The Planning Inspectorate  
National Infrastructure Planning  
Temple Quay House  
2 The Square  
Bristol  
BS1 6PN  
United Kingdom

JNCC Reference: OIA-10356  
JNCC Registration ID Number: 20048439  
PINS Reference: EN010137  
Date: 27 August 2024

## **Mona Offshore Wind Project Development Consent Order Application – Environmental Statement and Management Plans – EN010137 – Response to comments on Relevant Representation**

Figure 1.1: Designated sites in close proximity that are covered in this apportioning assessment in relation to the Mona Array Area.

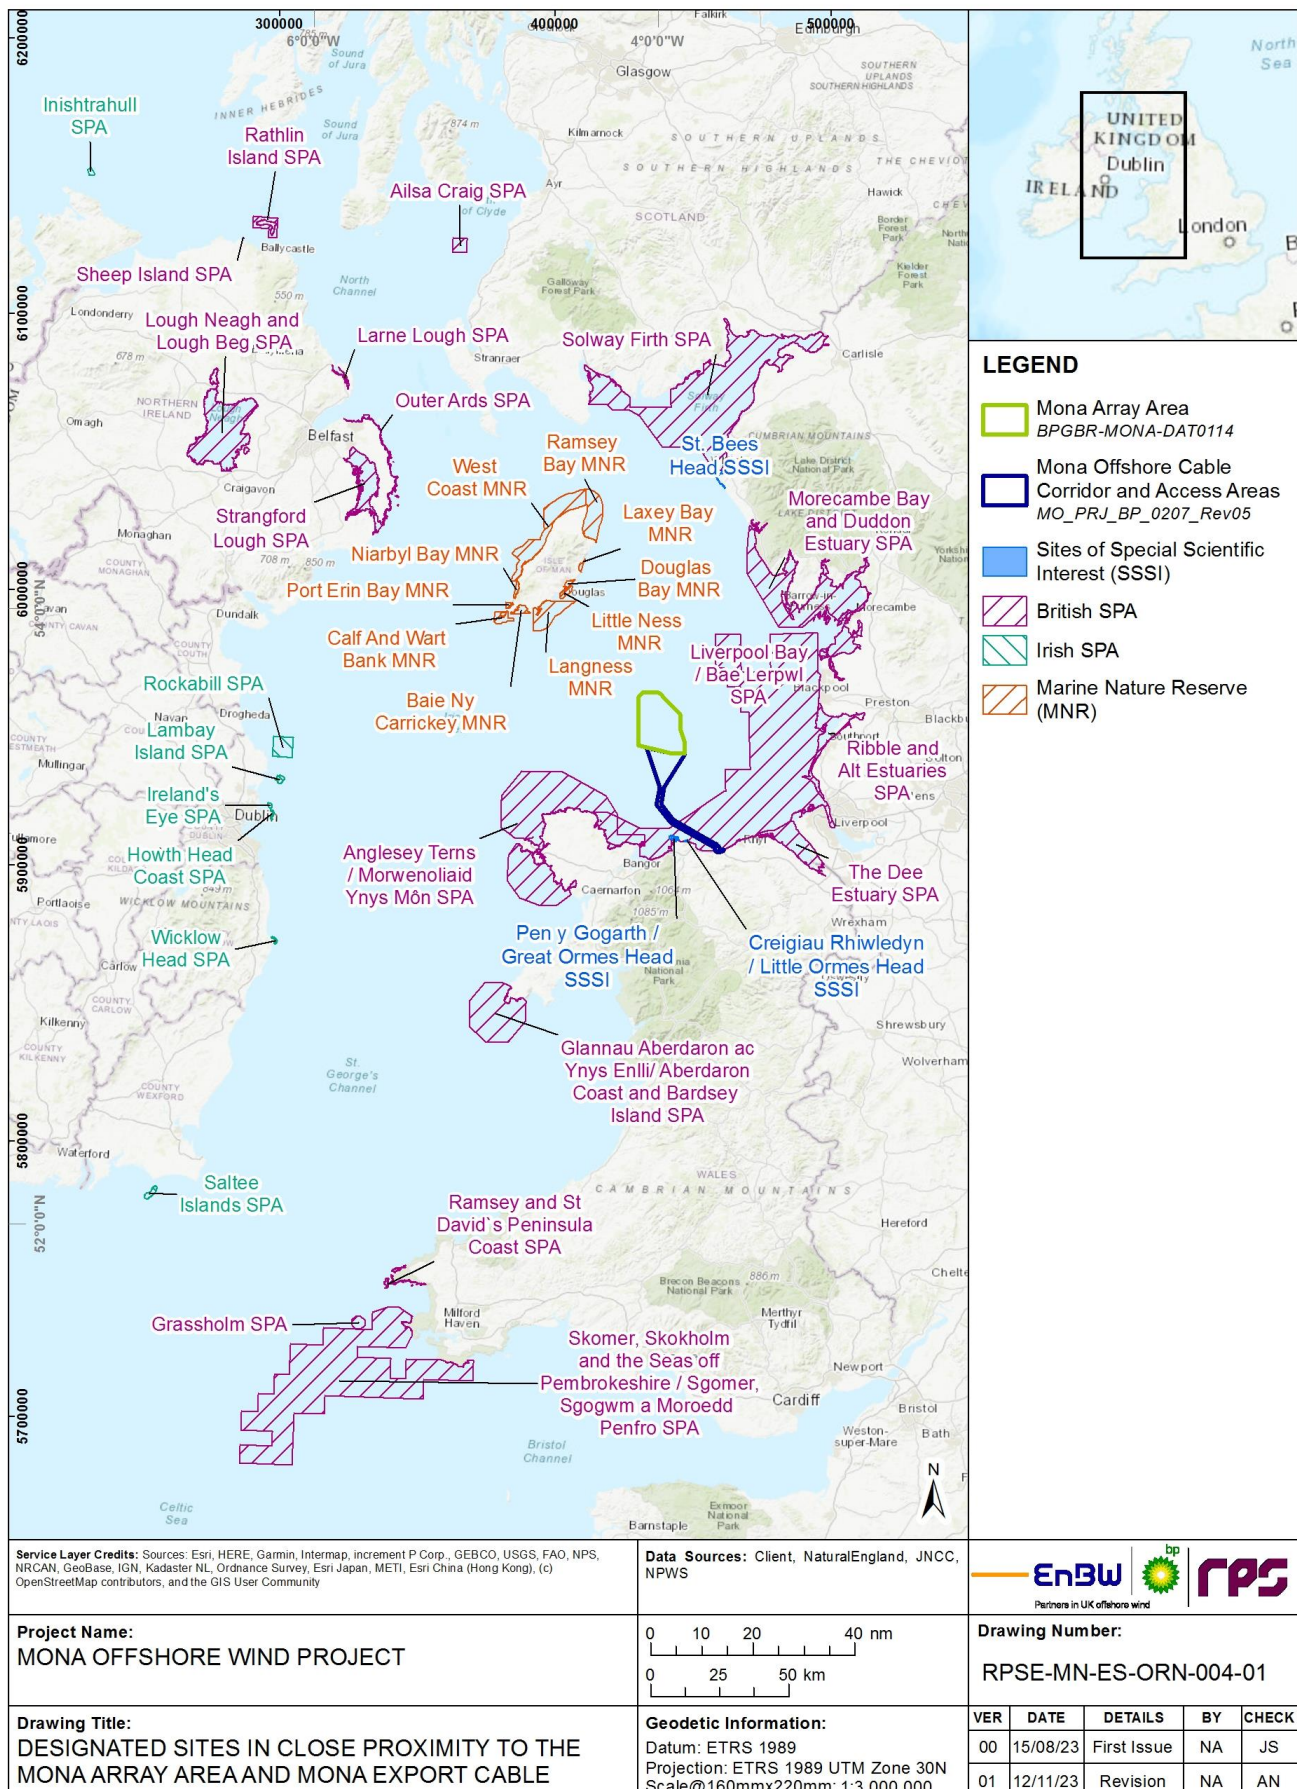
RR-033.22	Volume 6, Annex 5.5: Offshore ornithology apportioning technical report Table 1.4: The last column in Table 1.4 should be titled "Proportion of adult birds (%)" not "Proportion of immature birds (%)".	The heading of Volume 6, Annex 5.5: Offshore ornithology apportioning technical report (APP-095) Table 1.4 should read "Proportion of adult birds (%)". This will be included in the Errata document submitted at Deadline 1.	We thank the Applicant for this clarification.
RR-033.23	Section 1.3.3: No information is provided on the number of adults and immatures identified from Digital Aerial Surveys (DAS). Without an understanding of the number of birds identified to age classes, as a proportion of the total number of birds (per species), it is hard to know whether a representative sample was identified, and	The number of identified adults and immatures for northern gannet, black-legged kittiwake, herring gull, great black-backed gull and lesser black-backed gull from the site-specific Digital Aerial Surveys (DAS) is provided in table 1.4 of Volume 6, Annex 5.5: Offshore ornithology apportioning technical report (APP-095). Also included is the number of birds for which age could not be identified. The last column of table 1.4 Volume 6, Annex 5.5: Offshore ornithology	Volume 6, Annex 5.5: Offshore ornithology apportioning technical report (APP-095) Table 1.4 of provides the following information: <ul style="list-style-type: none"> <li>the number of birds which were not identified to age classes from DAS</li> <li>the percentage of adult birds identified from DAS</li> </ul>

RR-033.24	<p>Section 1.3.3: We disagree with the calculation of kittiwake age classes. This approach was not raised by the applicant during EWG meetings or subsequently, and therefore JNCC has not agreed to this approach. The Hornsea Offshore Wind Farm Project Two approach to apportioning to age class referred to in Section 1.3.3.5 relies on reliable counts of first year birds, i.e. in the case of kittiwake first summer birds which by August of that year have largely transitioned to adult plumage and therefore indistinguishable from adults. Therefore, the identification rate of first summer kittiwake is questionable and calculations derived from</p>	<p>The Applicant has provided the scientific rationale for this approach in paragraph 1.3.3.4 in Volume 6, Annex 5.5: Offshore ornithology apportioning technical report (APP-095).</p> <p>The Applicant stated in paragraph 1.3.3.4 "Coulson (2011) presents evidence that shows that immature kittiwakes, particularly those in their second and third years, frequent natal waters, with older immatures increasingly populating breeding colonies. Using site-specific survey data to calculate age class proportions for the breeding season will lead to an underestimation of second- and third-year immatures. Utilising the current approach (i.e., using proportions of adult and immature birds from DAS to age-class birds) will therefore lead to an overestimation of</p>	<p>The method used by the Applicant relies on reliable counts of first year birds. However, in the case of kittiwake first summer birds have largely transitioned to adult plumage by August of that year and are indistinguishable from mature adults. Therefore, the identification rate of first summer kittiwake is questionable and calculations derived from this e.g. applying survival rates to define an age class structure, is also questionable.</p> <p>We also have concerns that very low number of juvenile kittiwakes in the Mona site-specific surveys were aged. Additionally, the juvenile survival rates (0-1 year) given in Horswill &amp; Robinson (2015) are very</p>

Reference	Relevant Representation Comment	Applicant's response	JNCC's response
		inform age structure does not impact the conclusions of the final assessment for black-legged kittiwake and all assessments and their conclusions remain valid.	
RR-033.25	Section 1.3.3: We disagree with the methods of apportioning impacts between adults and immatures during the nonbreeding season. We advise that the same approach is taken as for the breeding season, as has been advised previously during EWG meetings and correspondence, by using the proportions of adults and immatures identified by surveys, and otherwise assuming all adult-type birds are adults.	The calculation of apportioning values for non-breeding seasons has followed the approach used previously in the application for Development Consent for multiple offshore wind farms (e.g., East Anglia THREE Ltd., 2015, Outer Dowsing, 2024) and is advised for use by Natural England (Parker et al., 2022). For apportionment, the contribution of adult birds from an individual designated site, as estimated by Furness (2015), to the relevant BDMPS population for each species/season combination is divided by the total BDMPS population. This follows advice received by NRW during the EWG03 (section D.4.1 Meeting minutes of Technical Engagement Plan Appendices Part 1 (A to E) (APP-042).	<p>We thank the Applicant for their response, but are unclear whether their response addresses the point raised in this Relevant Representation or was written in response to RR-033.26 (and vice versa, i.e. that the Applicant's response to RR-033.26 is in fact a response to RR-033.25?).</p> <p>The approach advised by Natural England suggested in the Applicant's response to RR-033.25 is in regard to the method of apportioning impacts to SPAs during the non-breeding season. This addresses and satisfies RR-033.26, but does not address nor satisfy RR-033.25.</p> <p>We therefore repeat and clarify our original comment RR-033.25.</p> <p>We disagree with the method used to assign age classes in the non-breeding season. It is stated in section 1.3.3.8 of Volume 6, Annex 5.5: Offshore ornithology apportioning technical report (APP-095) that "In the non-breeding season, age-class was based on Furness (2015)". This goes directly against SNCB advice given previously, which is outlined in Table 1.1 of the same document. JNCC advice is that species that can be identified to age classes from digital aerial surveys should be done so. If it is not possible to assign age classes from digital aerial surveys, then all birds should be assumed to be adults. This applies to both the breeding and the non-breeding season.</p>

RR-033.26	Section 1.3.5: We disagree with the method of apportioning impacts to SPAs during the non-breeding season. We recommend that to calculate apportion impacts to colonies in the non-breeding season, this should be based on the proportion of the SPA adult birds, across the BDMPS total of birds of all ages, for each relevant non-breeding BDMPS season, as has been advised	The Applicant can confirm that the impacts apportioned to each SPA in the HRA Stage 1 Screening Report [APP-034] and HRA Stage 2 Information to Support an Appropriate Assessment, Part Three: Special Protection Areas and Ramsar Sites Assessments (APP-033) are for adult birds only in both the breeding and nonbreeding period.	<p>The Applicant's response does not appear to answer our original query. Or is perhaps this response is written in the wrong row and should instead be an answer RR-033.25, and vice versa the Applicant's response to RR-033.25 is in fact a response to RR-033.26?</p> <p>However, the reasoning given in the Applicant's response to RR-033.25 sufficiently answers our query</p>
